**RFI**

RFI #: 61  
Date: 2/22/2012  
Job: EB-02 Keller Springs Lofts  
Phone: 877-777-5115

Subject: Fire Extinguisher Cabinets Locations

Subject: Elevation conflict between sheets 3.1A and 2C

DATE	08-05-2011	SHEET NUMBER	3.1
PROJECT	11129

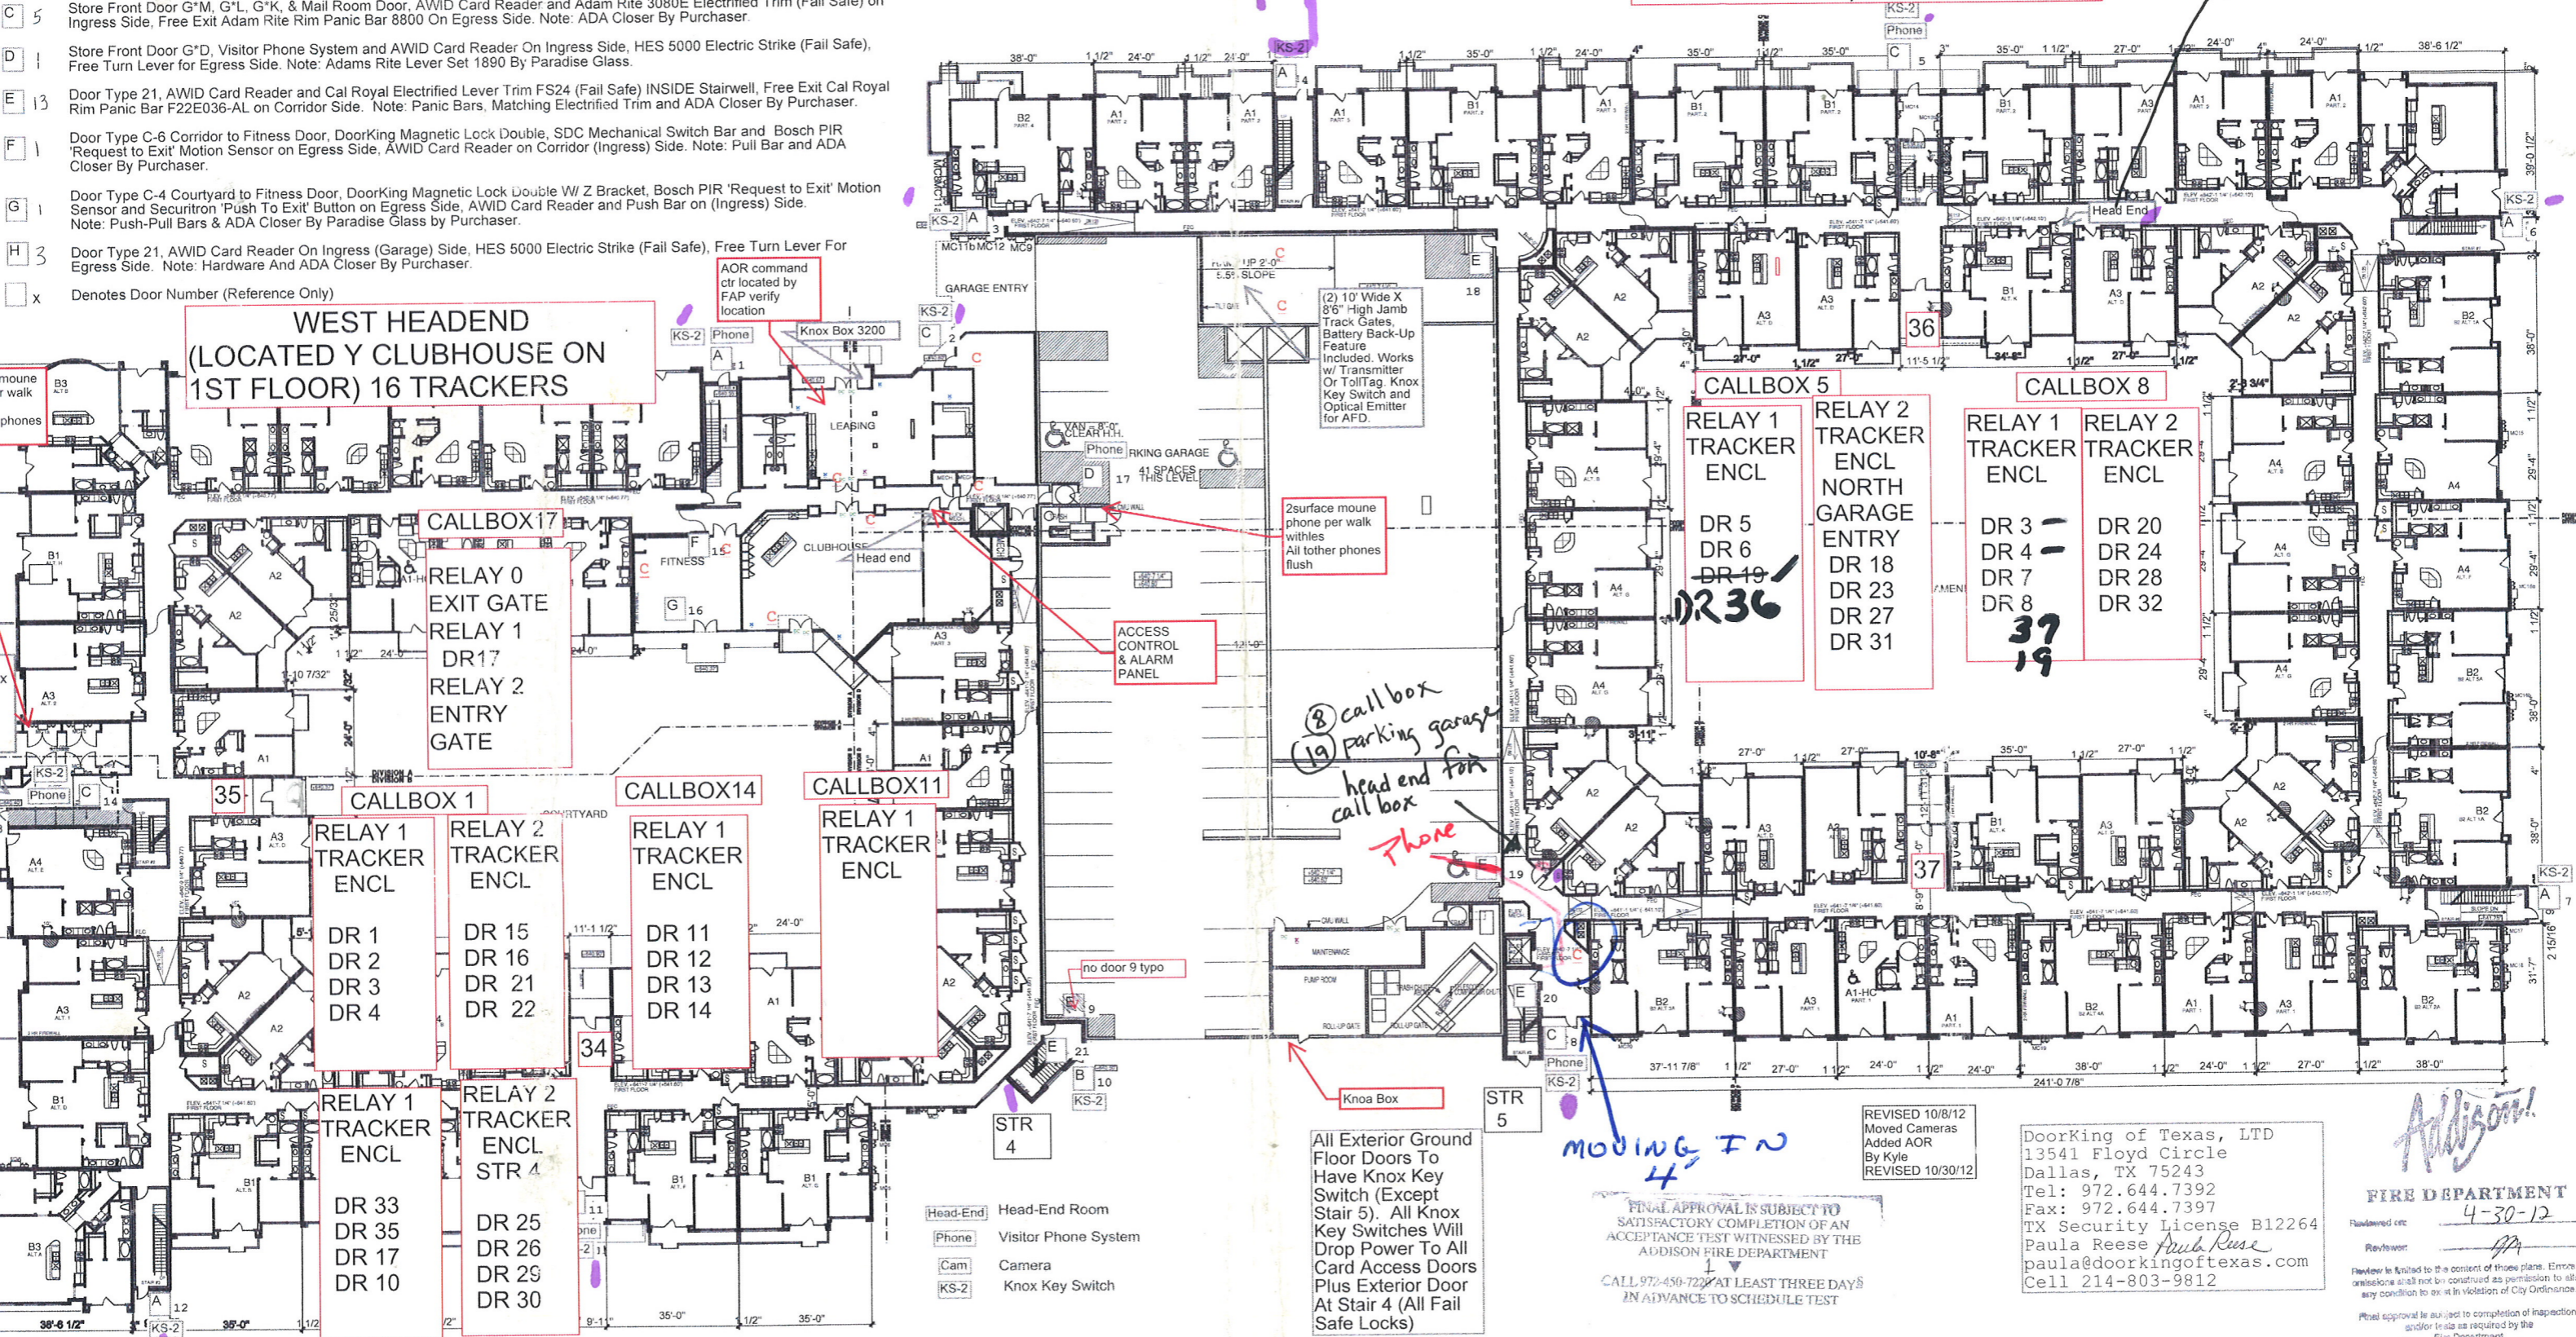
**Request:** Date Required: 2/29/2012  
1) There are some inconsistency's with plans for FEC locations in corridors.  
3.1A shows 2 FEC  
3.2A shows 1 FEC  
3.3A shows 1 FEC  
3.4A shows 2 FEC  
Do you want 2nd FEC added for 2nd & 3rd floors?  
2) On sheet 3.4F - FEC mark is missing on A4 Air G wall.  
The FEC is shown on 1st, 2nd and 3rd floors, does the FEC need to be included at 4th floor?  
Please verify all sections for coordination and consistency.  
3) Do we need fire extinguishers in club/leasing? We have assumed 1 for club and 1 for leasing.  
4) Do we need FE in parking garage and if so what type of mounting?  
**Requested by:** Bryan Pickler  
Embrey Partners, Ltd.

**Request:** Date Required: 3/22/2012  
On sheet 3.1A at stair #1 we have a F.F. elevation 640.55 at the inside of entry door. It also shows a F.F. elevation 637.85 on the exterior side of the door to the stairwell. On Landscape 2C the same are shown F.F. elevation 640.55 for both sides of the door to stair #1. Please review and designate the correct elevations. We will need a revised sheet to add to our project plans.  
**Requested by:** Bryan Pickler  
Embrey Partners, Ltd.

**Response:**  
1- Yes.  
2- Yes. I've checked all locations and the one's you mentioned are the only problem locations. I adjusted 2 other FEC locations by moving them a foot or so now all FECs line up in the same spot from floor to floor (except for the Club and Garage areas).  
3- I've placed the 2 FECs you mentioned in sheet 9.1  
4- Yes, we need them in the parking garage. I've updated the sheets to reflect this. Double check with your local Fire Marshall, but I'm confident that a surface mounting will be fine.

**Response:**  
The 640.55 elevation is correct on our drawing. I talked to Ryan at BGO and he agreed. The door and sidewalk are flush.
